Planning Application No: 3/2026/0256

Proposal: Proposed change of use of a dwelling house (C3) to a children's home (C2) for up to 2 young people between the age of 8 and up to 18.

Location: 36 Moor Field Whalley BB7 9SA

**PROPOSED SITE PLAN  
scale 1:200**

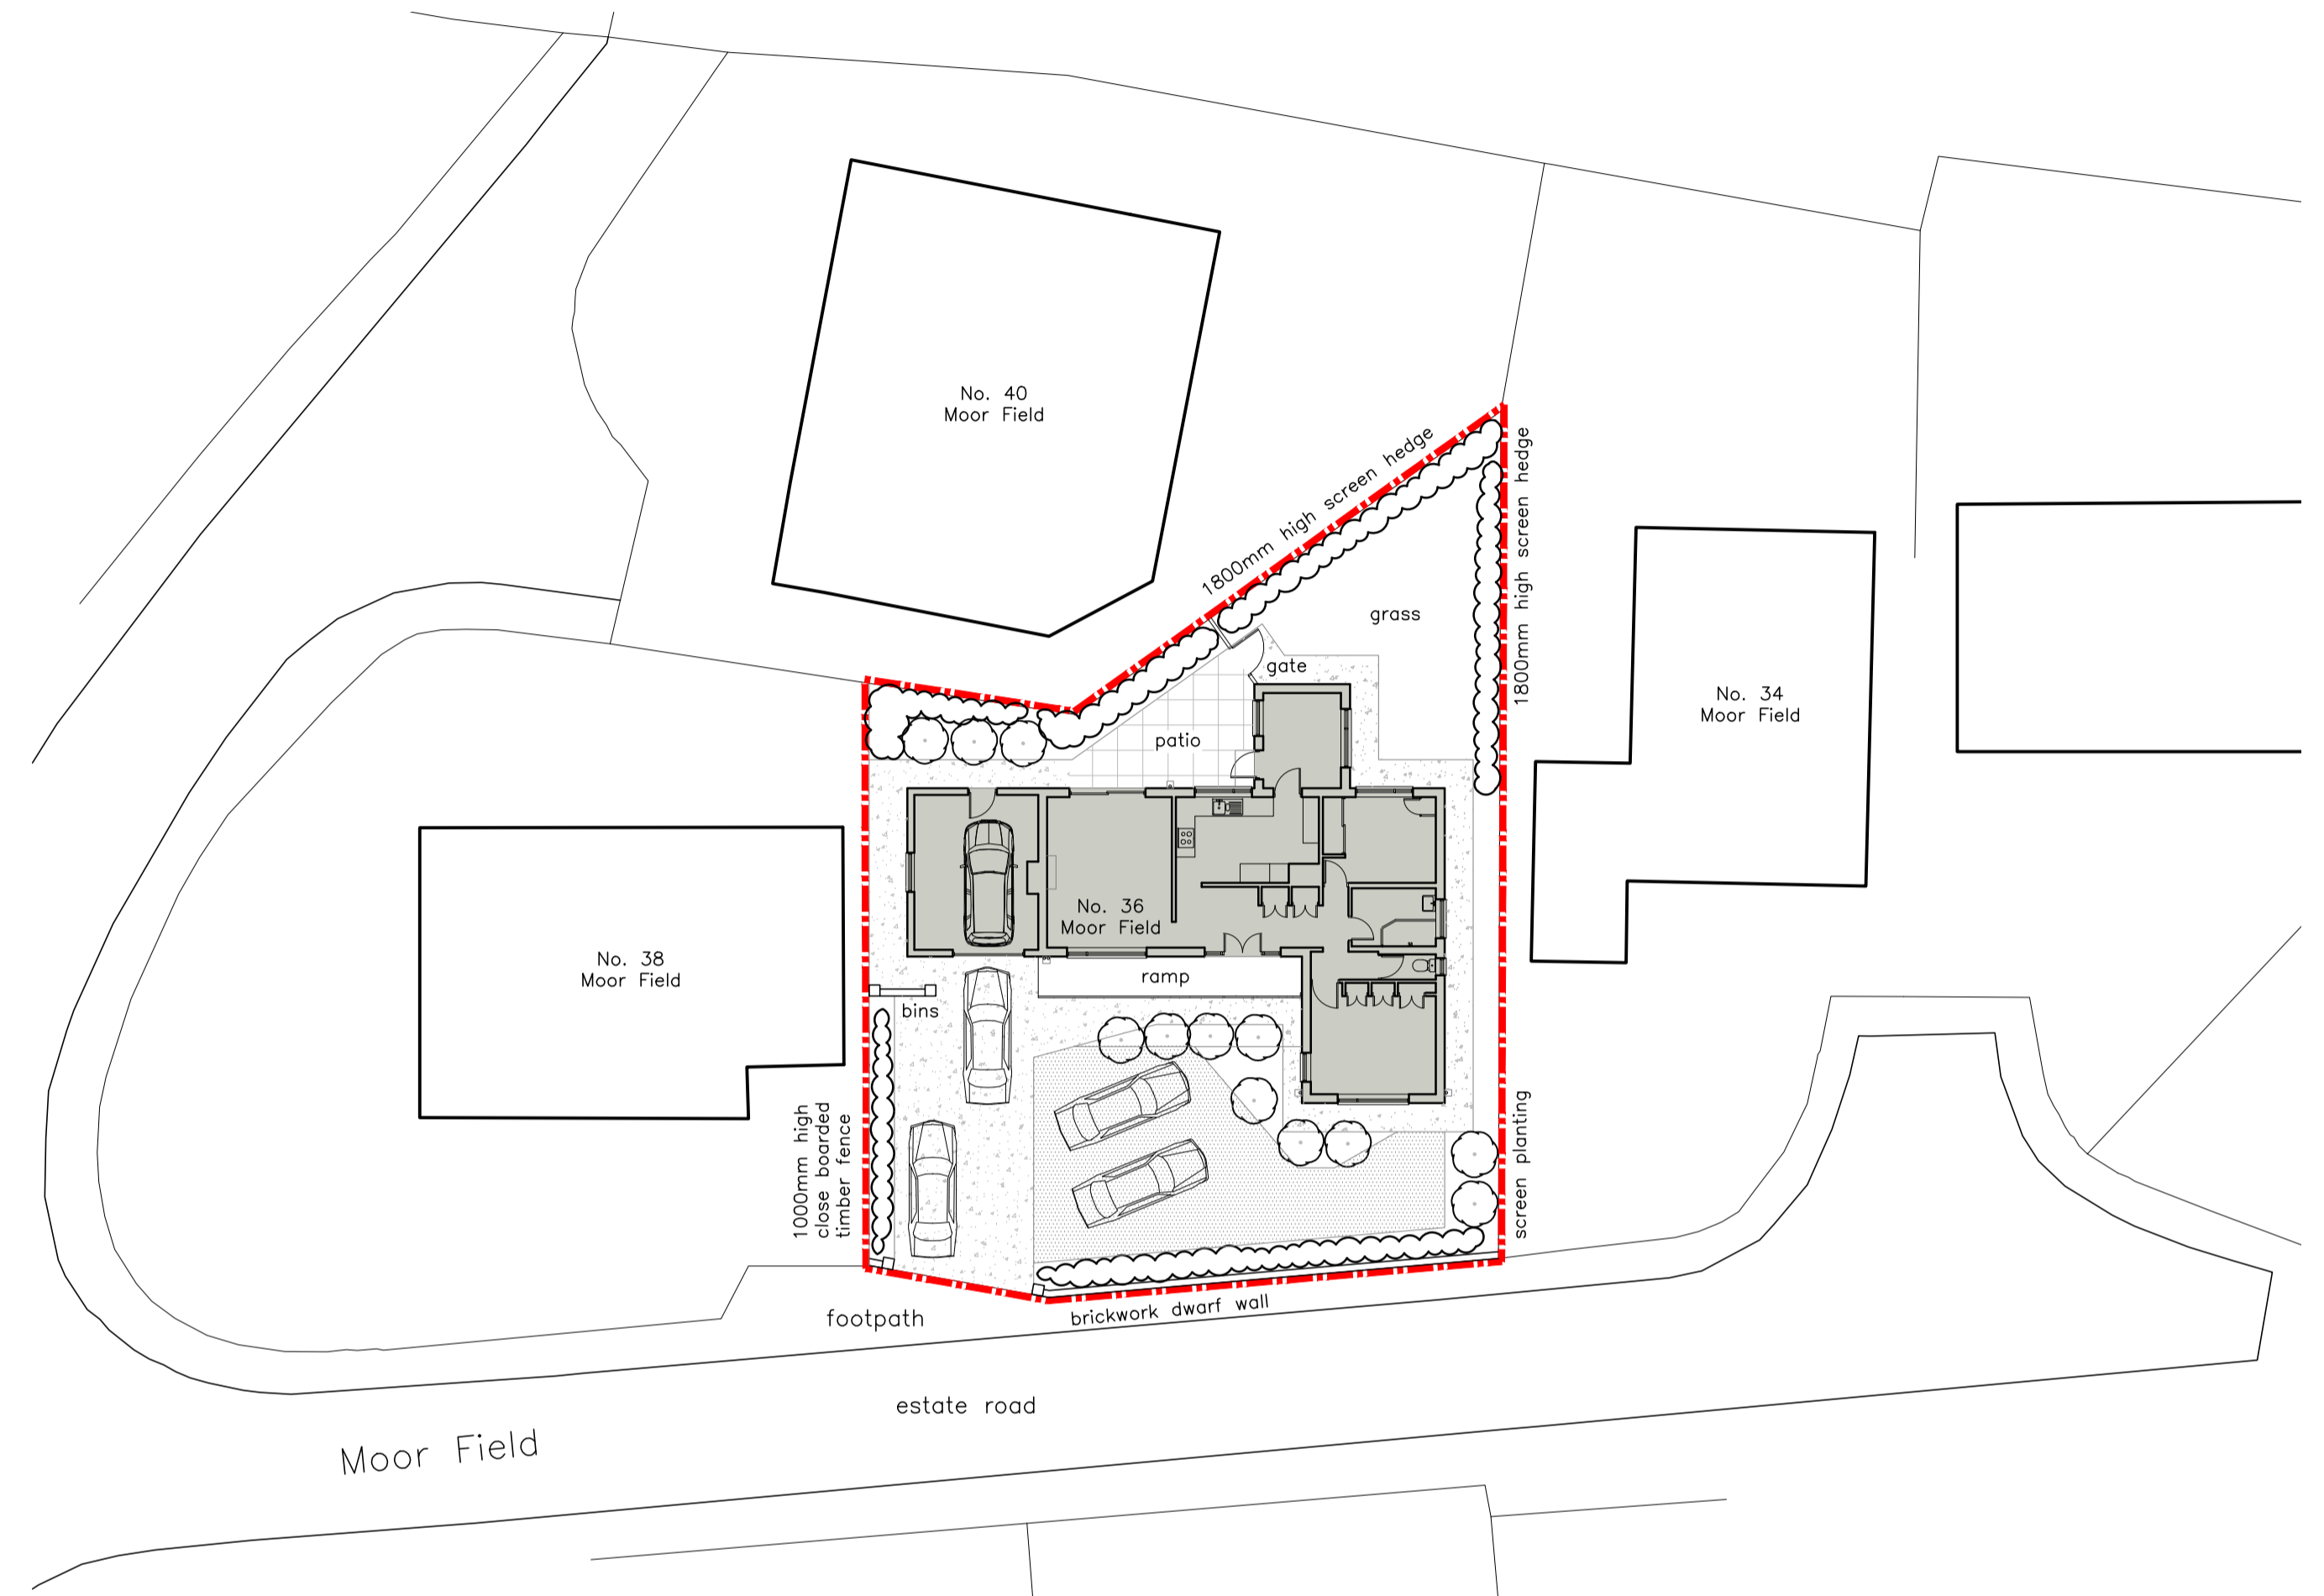
- The parking areas shown on the approved plans shall always remain available for the parking of four vehicles associated with the development. Reason: In order to ensure satisfactory levels of off-street parking are achieved within the site.
